Client: S.W. Cole Engineering, Inc.**Project:** 169 Newbury Street**SWCE Project #:** 16-0910**Date:** November 8, 2016**Subject:** Inspection of Field Weld**Report:** 001

S101

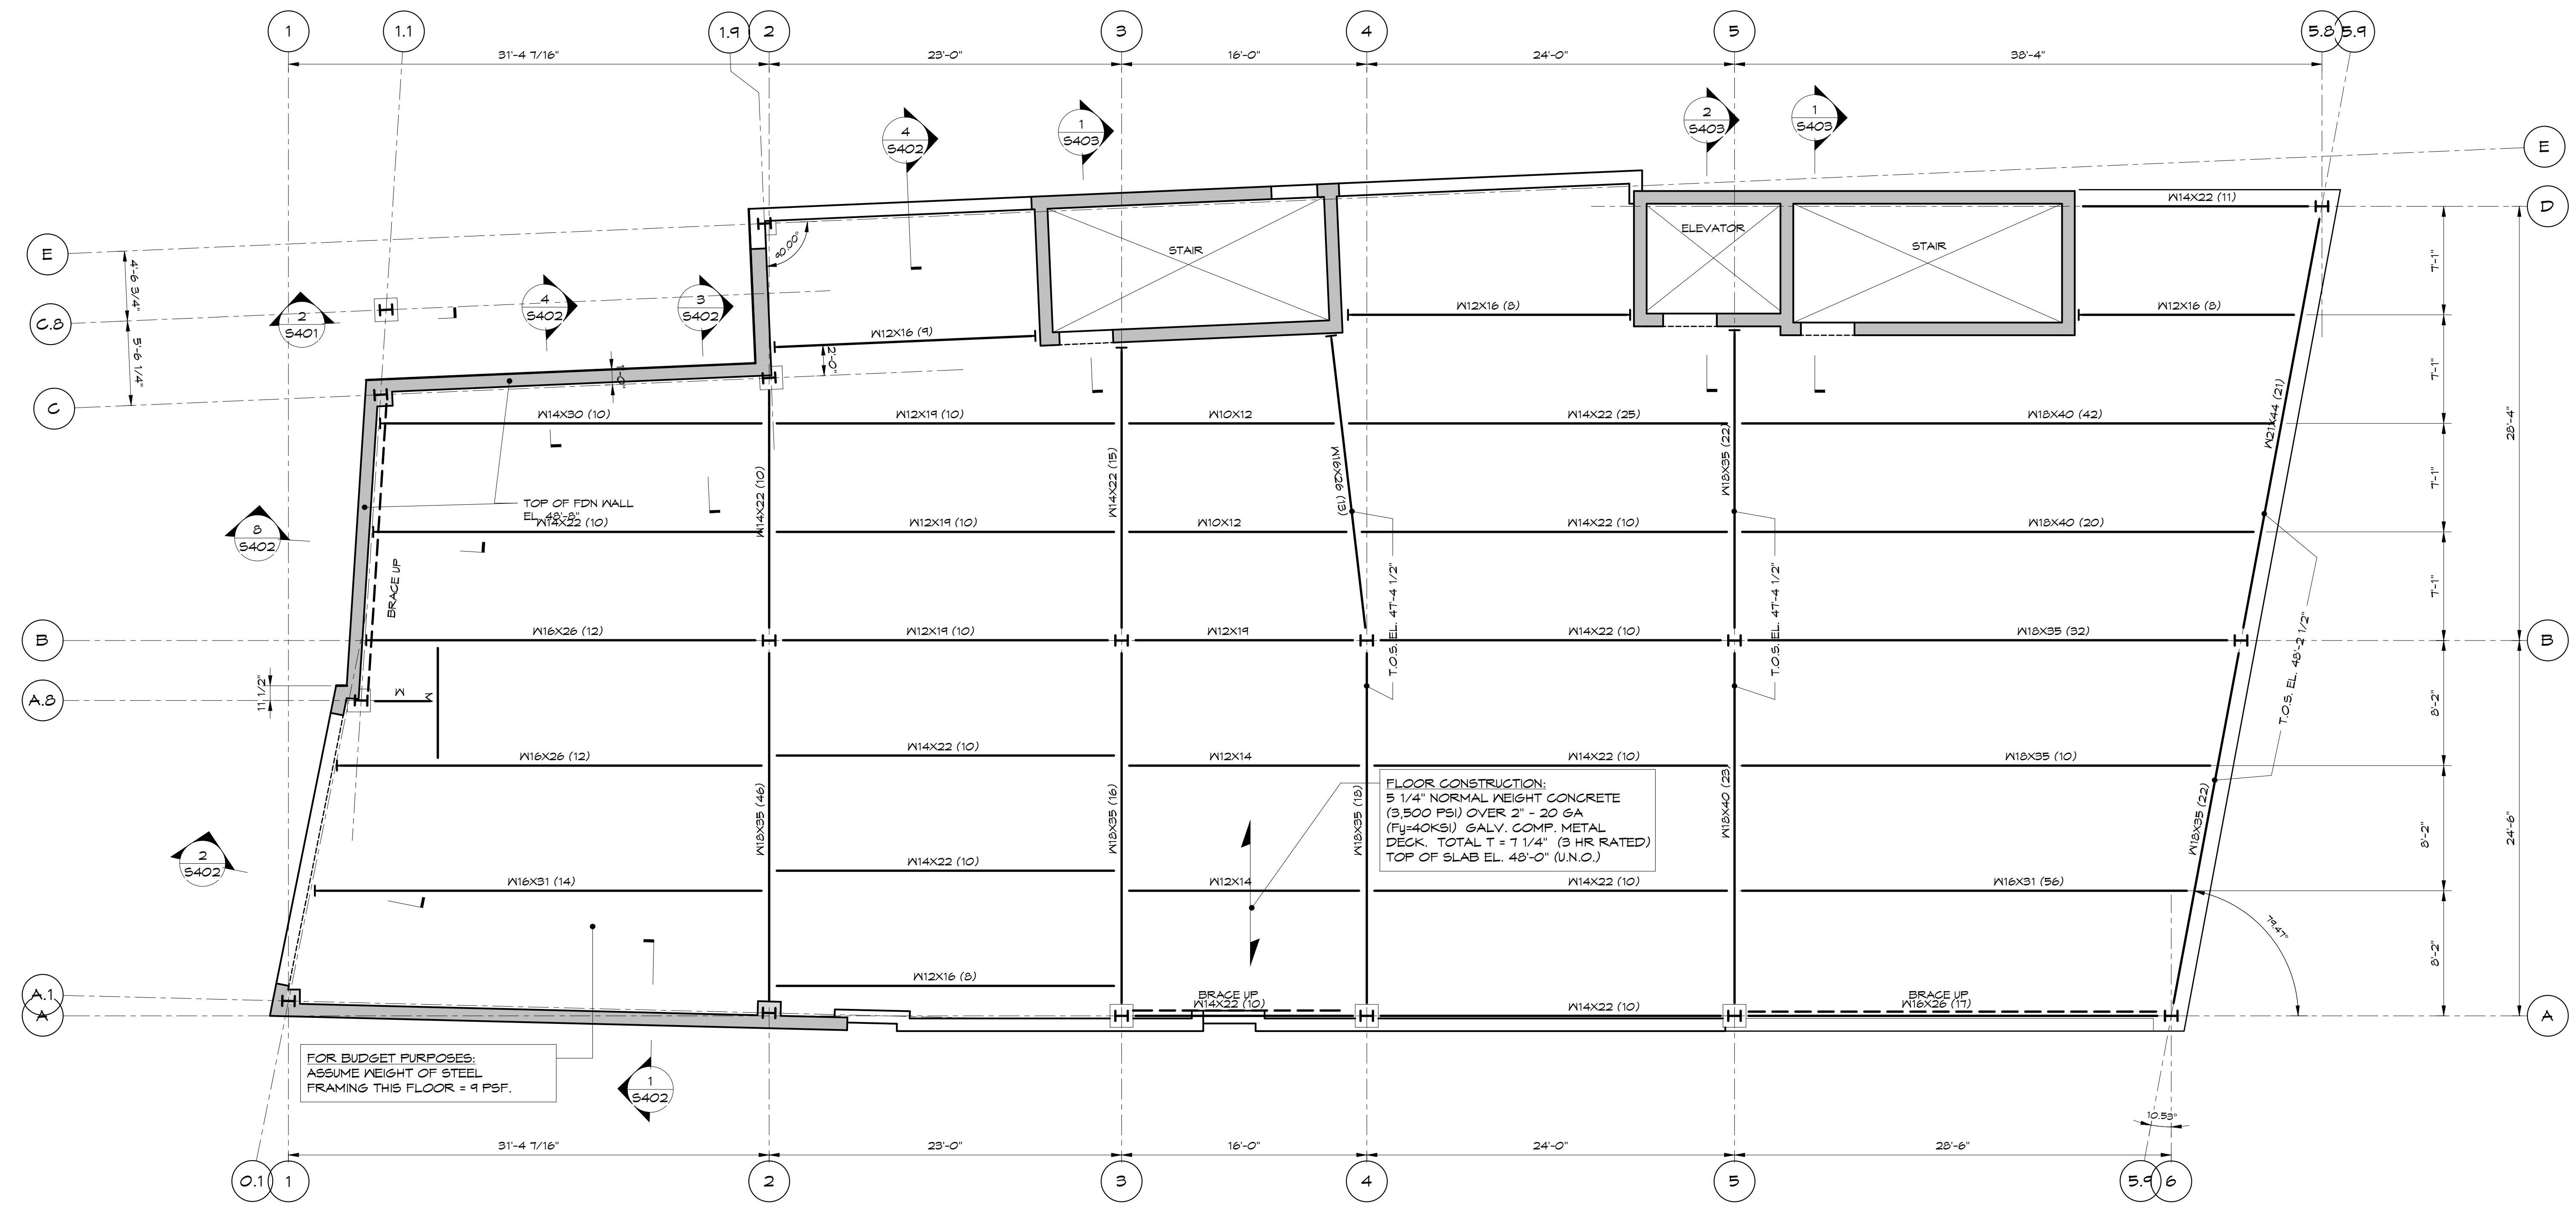
The weld in question was a spliced section to extend an embedded plate at first floor location D.3/5 (reference RFI #39). There was no field sketch available. We were advised that a complete penetration weld was required (see photograph below).

The weld was visually acceptable per AWS D1.1 visual acceptance criteria.

Ultrasonic testing indicated a through thickness weld of approximately .750" had been obtained. No internal defects were apparent.

Please note that this was an open root joint and therefore per AWS D1.1 could not be considered a complete penetration weld as there was no backing used and no access for backgouging.

The weld appears to meet the intent of the EOR. The superintendent and erector were advised of our observations.
